Our Ref: FG/86/15/HH

**Town & Country Planning Act 1990 (as amended)
Town & country Planning (Development Management Procedure) (England) Order 2015
Application for Householder Planning Permission**

Development Rooms in roof, raising ridge & installation of 6 No. dormers.
Location White Thorne The Warren Ferring

SIDE ELEVATION 1:100 SOUTH PROPOSED

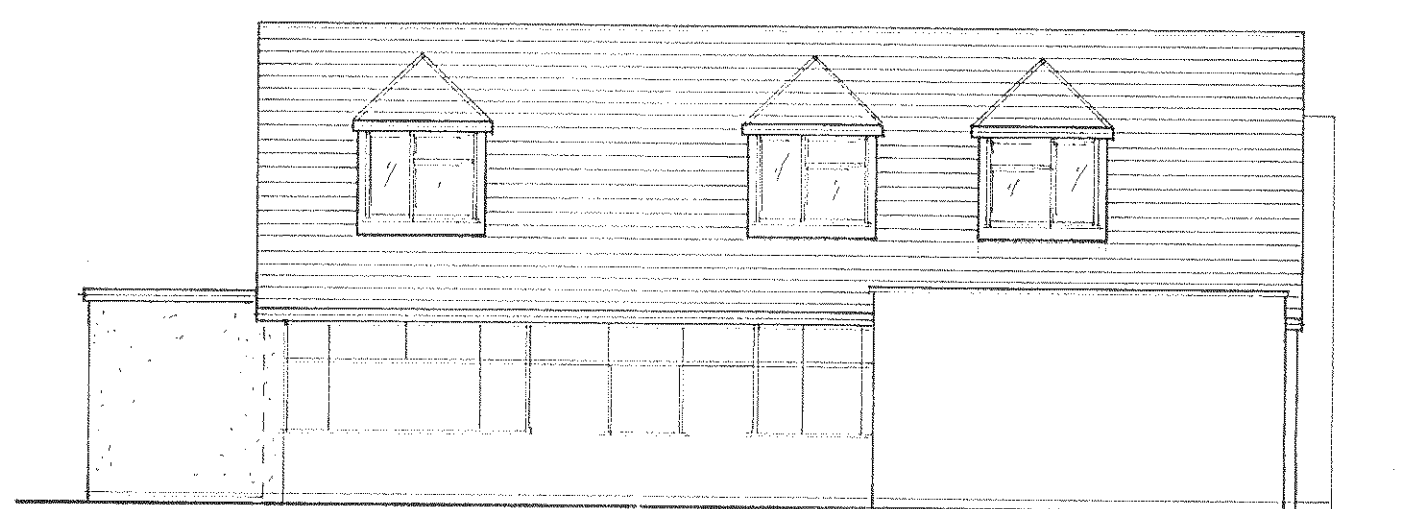
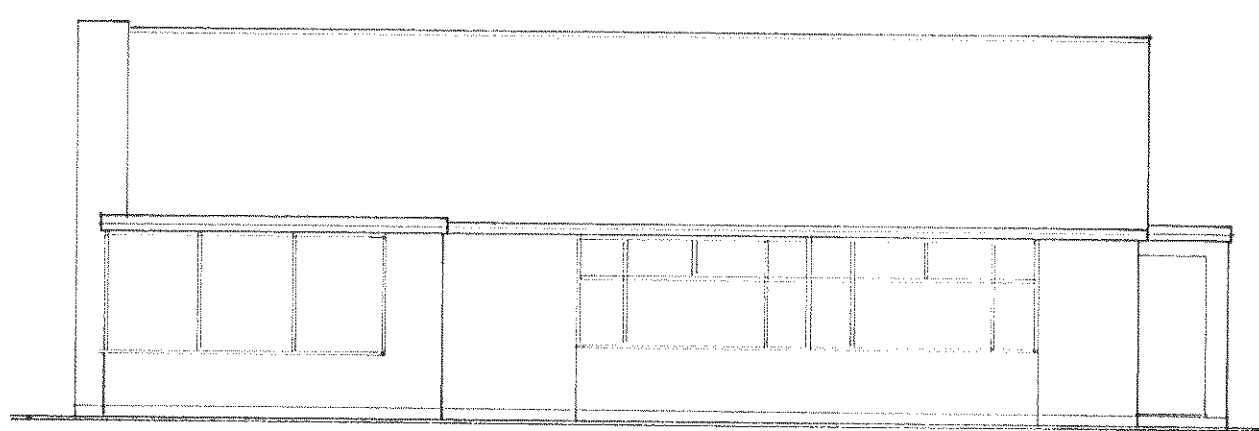
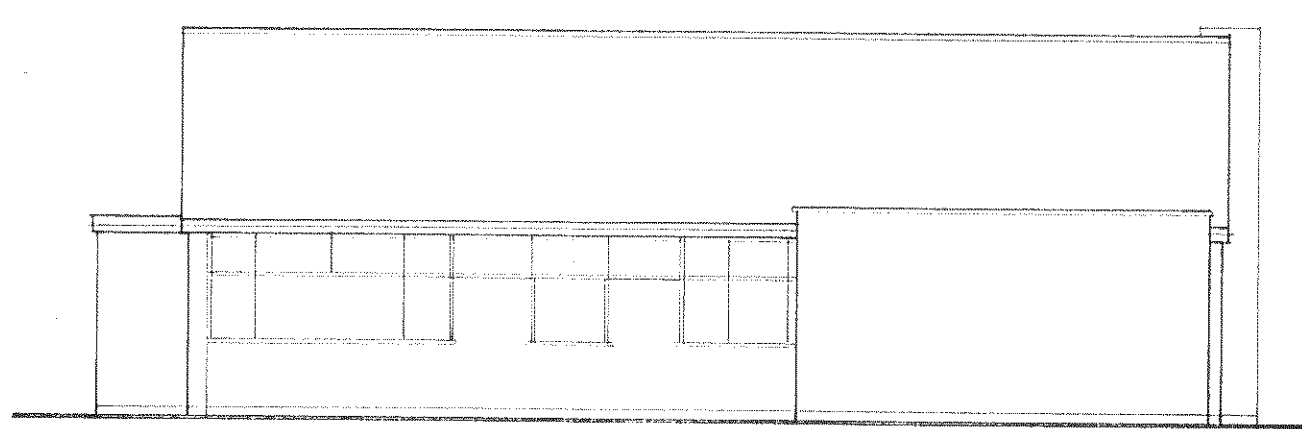
Please show the detail of the window framework on the existing and proposed north and south elevations.
